Rule 17 letter Responses Issued 21 April 2026

In response to the Examination Authority's Rule 17 letter questions issued on 21 April 2026, the MCA would like to comment as follows at Deadline 7, 29 April 2026.

Document Title: Areas of Safeguarded Water Depth Plan

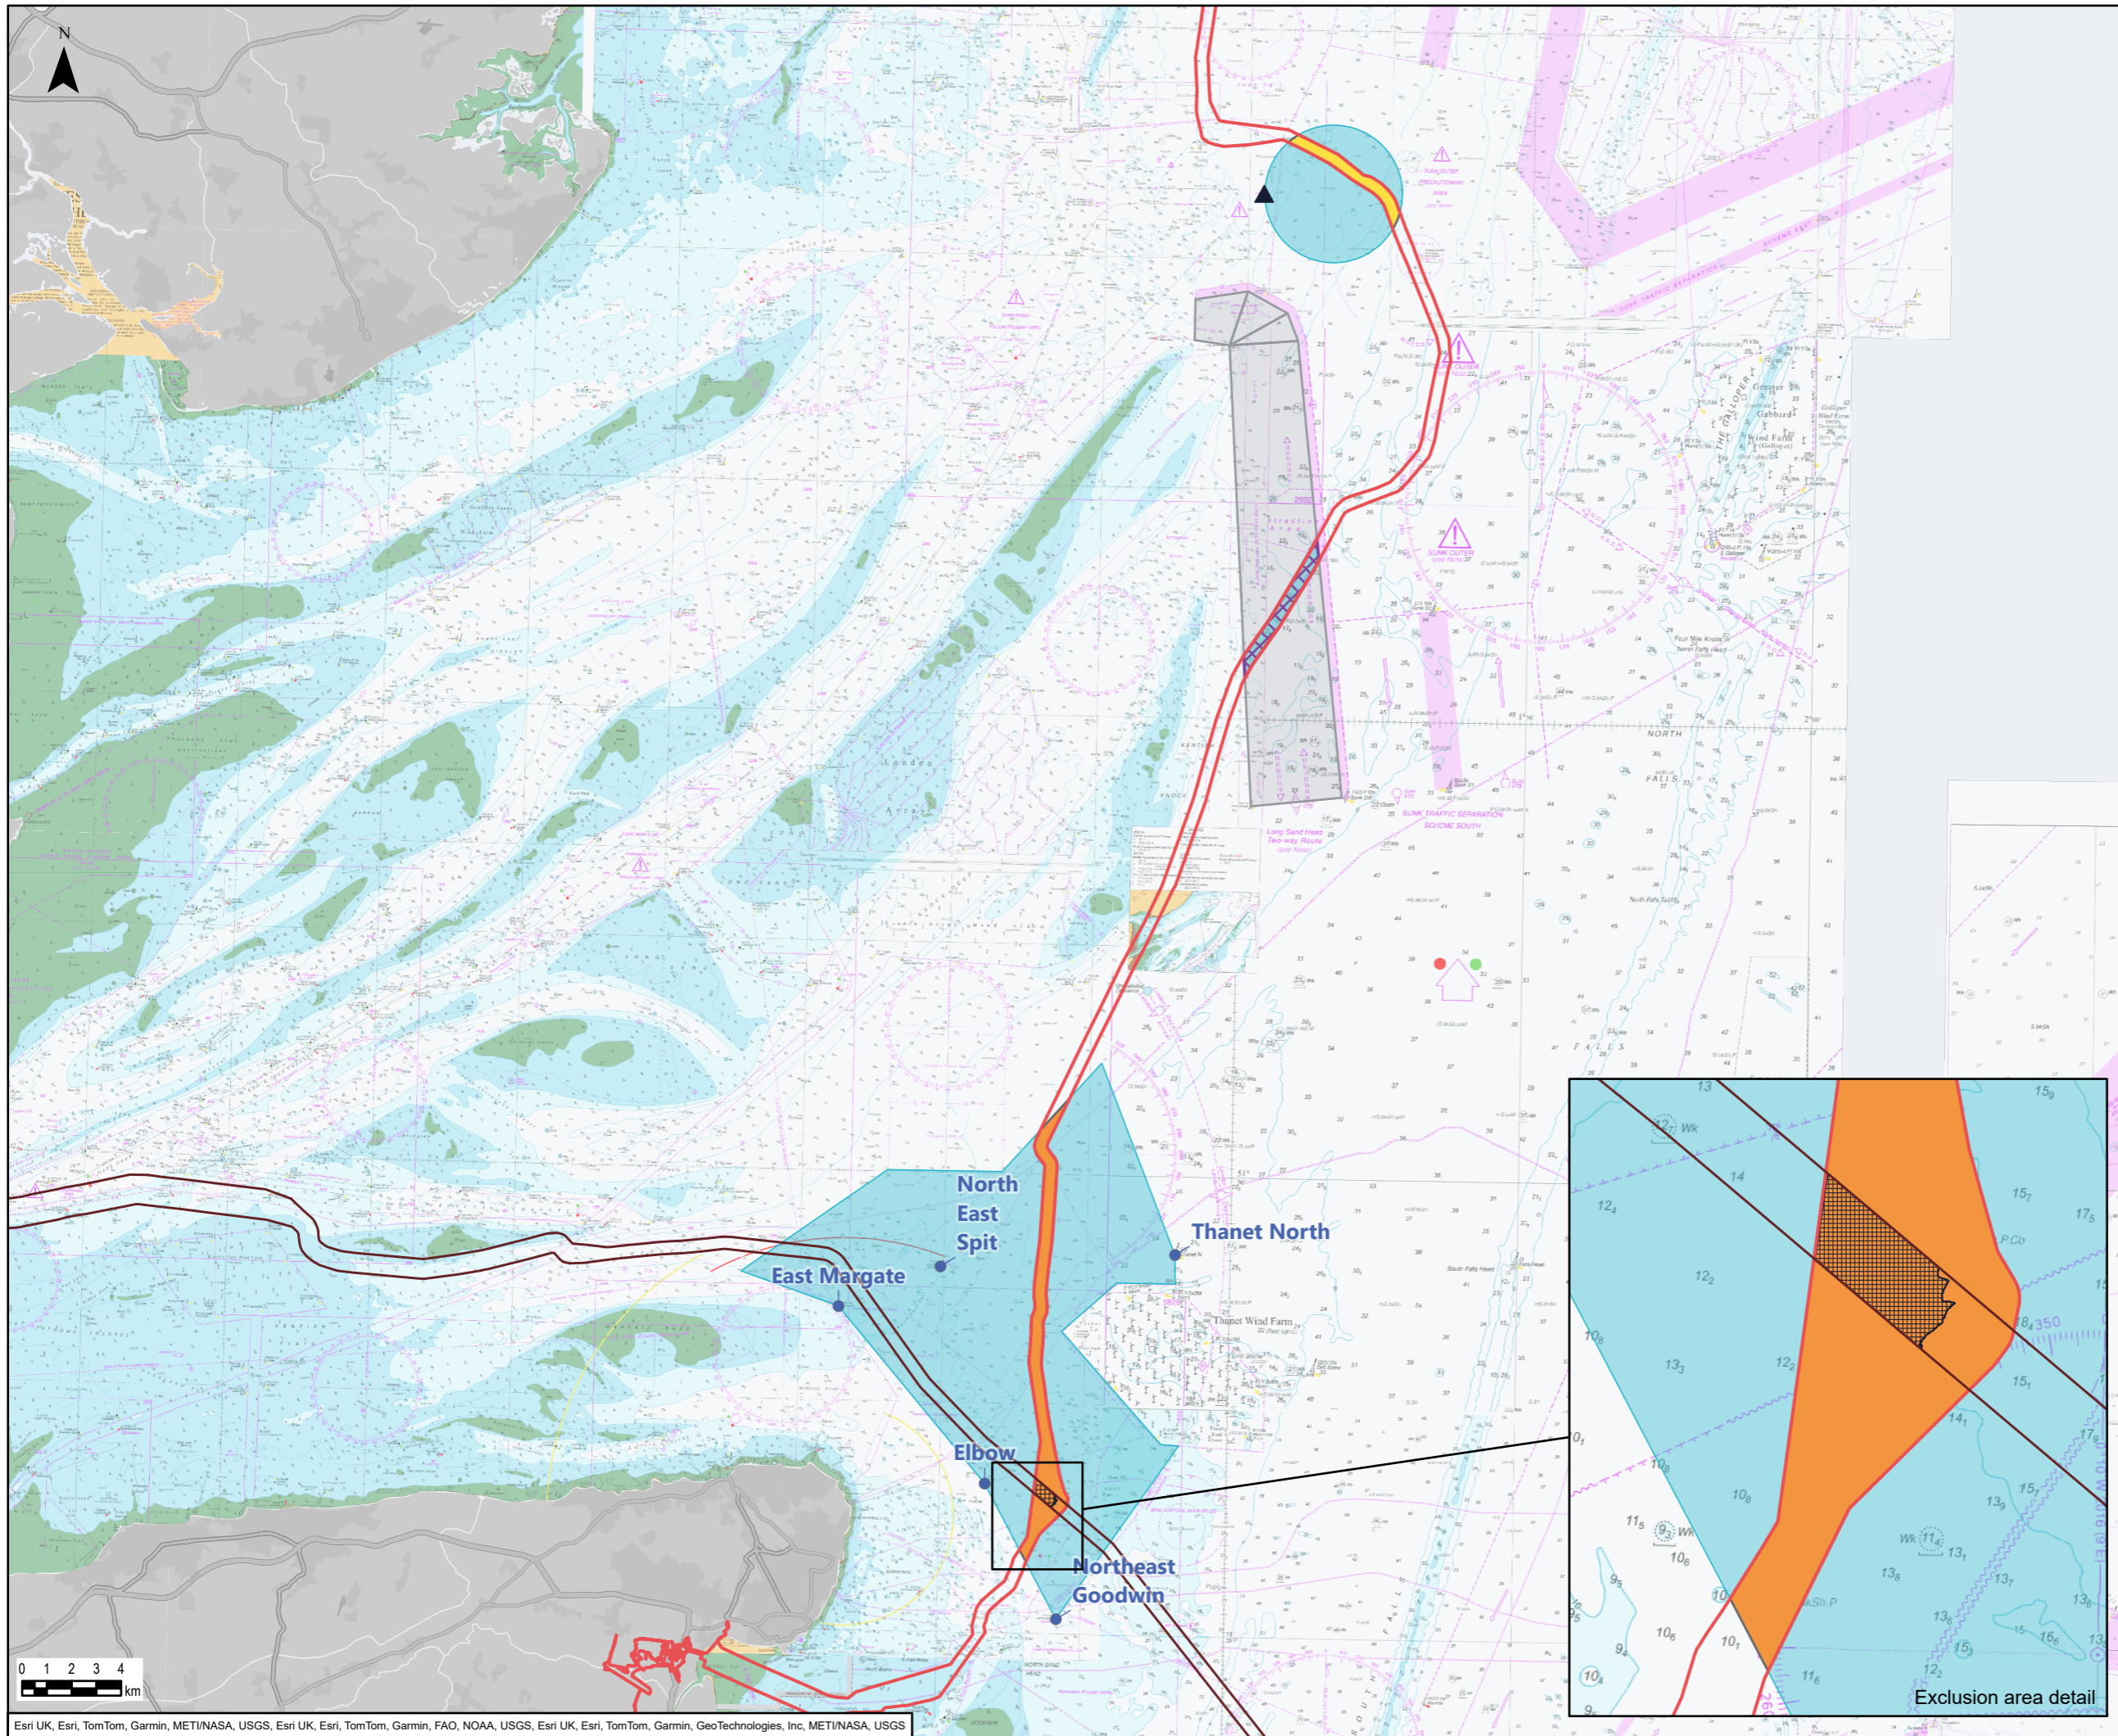
DCO DML	Securing the 5% reduction	With regards to Item 28 in the Schedule of ExA's recommended amendments to the applicant's dDCO submitted at deadline 6 [REP6-004]. The MCA is concerned that the ExA proposed DCO DML amendments may not appropriately capture Safeguarded Depth or 5% which ever provides the greatest depth.	The MCA has discussed and agreed the following wording with the PLA, in consultation with London Gateway: Condition 4(5) <i>In undertaking the licensed activities,</i> <i>(i) within the Areas of Safeguarded Water Depths the undertaker must not reduce existing water depths by more than 5% of navigable depth referenced to Chart Datum or below the depths required by Requirement 17 in Schedule 3 (whichever results in the greatest water depth); and</i> <i>(ii) outside these areas, the undertaker may not reduce existing depths by more than 5% of navigable depth referenced to Chart Datum unless the MMO agrees a depth greater than 5% in writing in consultation with the MCA and Trinity House.</i>

<p><i>Condition 12 (3) In undertaking activities under condition 12(2):</i></p> <ul style="list-style-type: none"><i>(i) within the Areas of Safeguarded Water Depths, the undertaker must not reduce existing water depths by more than 5% of navigable depth referenced to Chart Datum or below the depths required by Requirement 17 in Schedule 3 (whichever results in the greatest water depth); and</i><i>(ii) outside these areas, the undertaker may not reduce existing depths by more than 5% of navigable depth by reference to Chart Datum unless the MMO, the PLA, London Gateway Port Limited, MCA and Trinity House all agree to the additional reduction.</i>
--	--	--	---
